Recommendation Report for Lawful Development Certificate for a Proposed Use or Development

REF NO: R/83/13/CLP

LOCATION: 15 Fontwell Close
Rustington

PROPOSAL: Application for certificate of lawfulness for a proposed use - Replace rear garden fence to completely enclose rear garden

FENCE SHOWN IN RED
GATES SHOWN IN GREEN

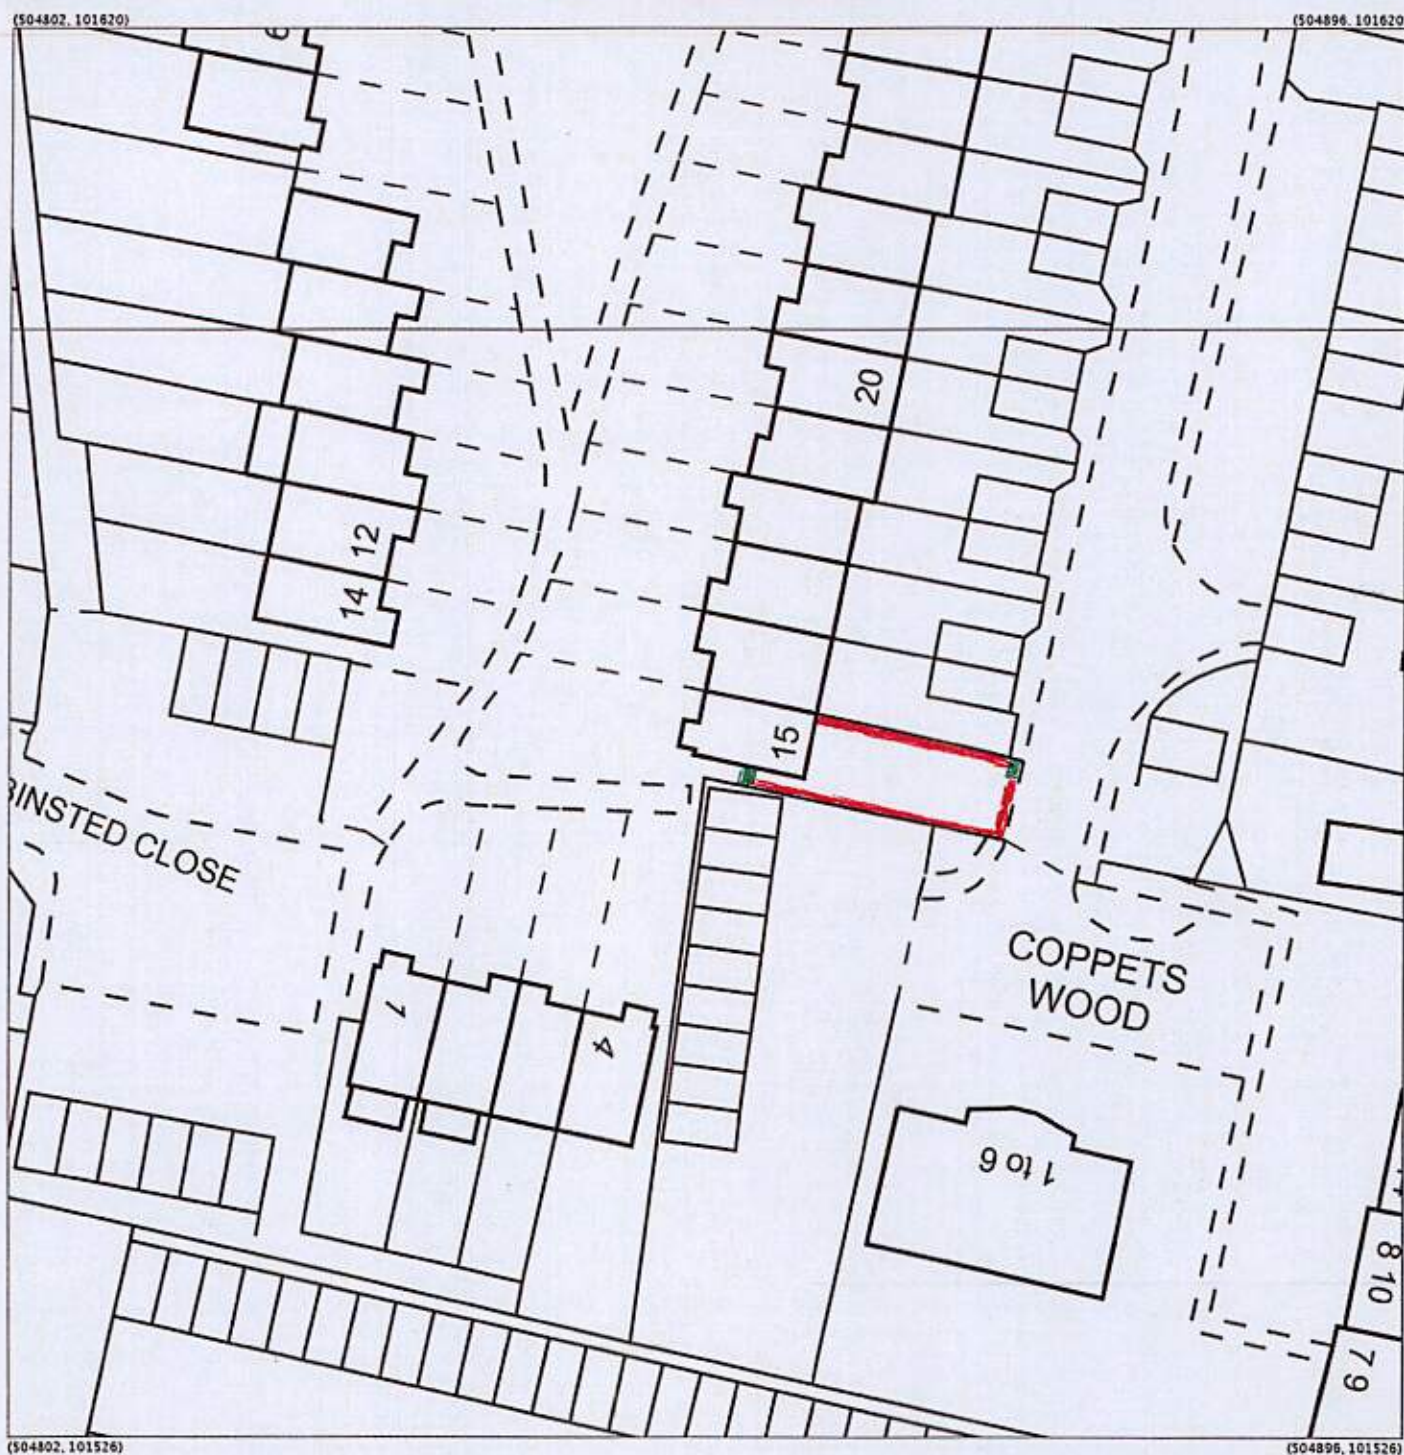
However, in any instance where the means of enclosure runs adjacent to a highway, the permitted height is reduced to 1 metre as per A.1(a). In this instance, it has been determined that the fencing running along the eastern site boundary would be in a position directly adjacent to the highway and, as such, would exceed the height permitted for boundary treatment in this position.

The section of fencing on the eastern boundary would run adjacent to the highway and exceed 1 metre in height, thereby falling outside of the thresholds allowed under The Town and Country Planning (General Permitted Development) Order 1995 (as amended) Schedule 2 Part 2 Class A.1 (a).

PROPOSED WOODEN CLOSE-BOARD FENCE
WITH WOODEN POSTS AND MATCHING WOODEN GATES
(GATES TO BE PEDESTRIAN WIDTH TO DIRECTLY
REPLACE EXISTING METAL AND WOODEN GATES)

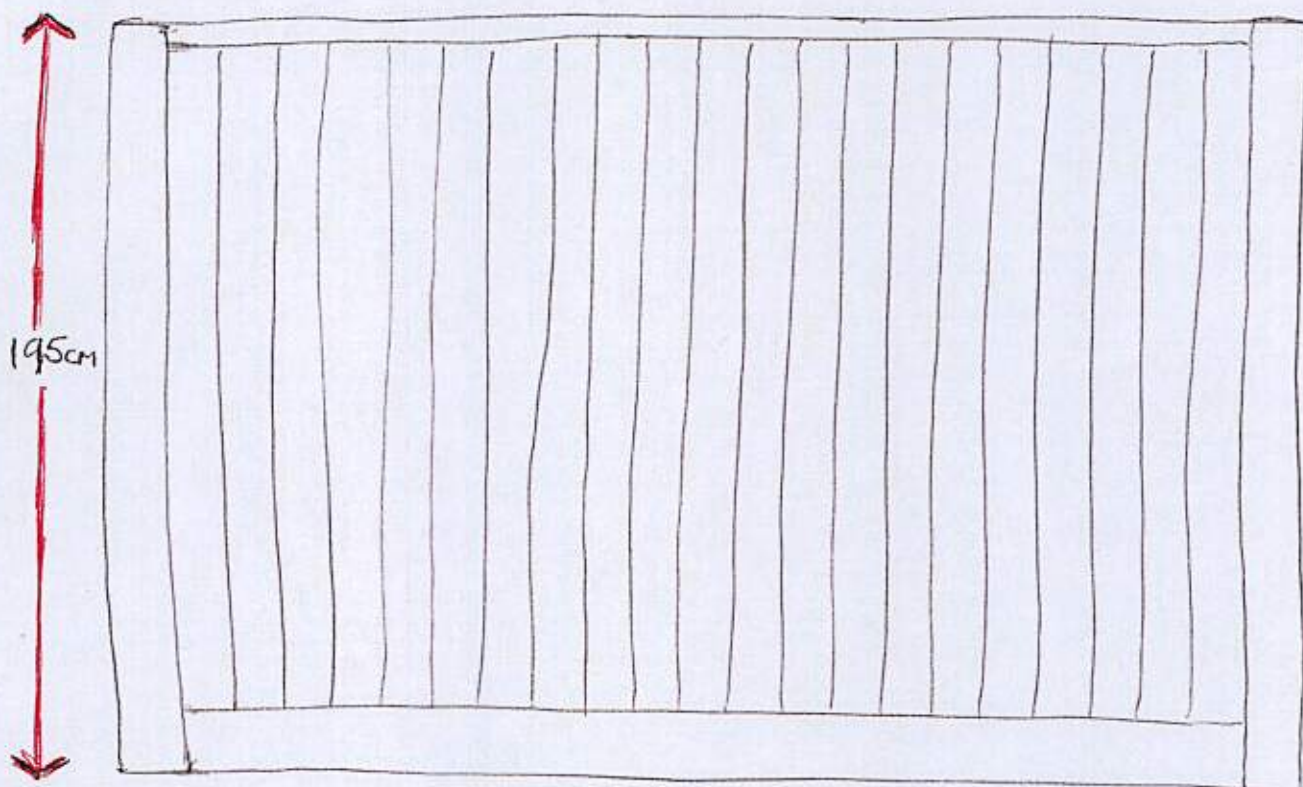
Criterion A.1(b) instructs that the maximum height above ground level of any means of enclosure erected must not exceed 2 metres, if it is to be considered to be Permitted Development. Accompanying plans show that the proposed fencing is to be 195cm in height and, as such, would be within the parameters set out.
